From: Roger Spencer
Sent: 01 June 2017 13:13
To: Planning.Responses
Subject: Planning Application Ref: FG/198/16/PL

Further to my previous message (18/4/17) regarding the above, in particular the revised proposals, May I suggest a the following Condition to bring together the EA's requirement for minimum floor levels (in light of the flood risk) and to reduce the risk to the basement parking area.

PROJECT NO:	16/046
DWG. NO:	PL005

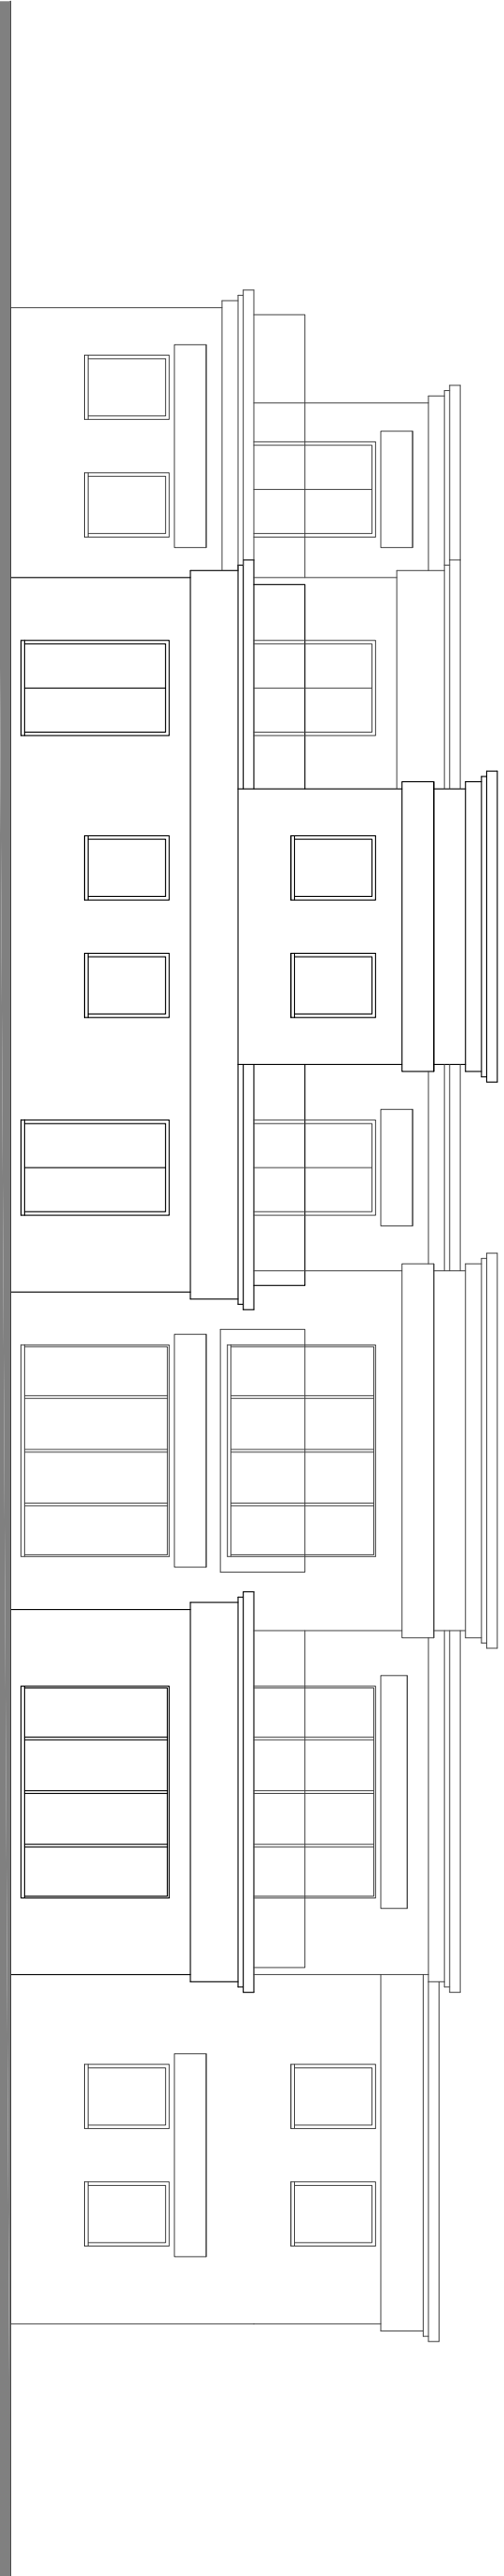
I note that the Environment Agency has requested a condition relating to the floor levels and I would agree with this. I would also suggest that the level of 5.8m is appropriate.

The development is provided with a means of preventing flood water from entering the basement. This should be to a height not less than the minimum floor level (mentioned elsewhere) and be continuous around the building, either at the boundary or by some other means within the site. The means of preventing flood water entering may be either permanent, demountable or in the form of a readily closed, solid gate (with suitable seals. If the means of flood resistance is not permanent then there shall be an operational / maintenance flood plan produced to the satisfaction of the Local Planning Authority. All residents shall be made aware of the risk and the need to close the barrier / gate and to comply with the contents of the Plan.
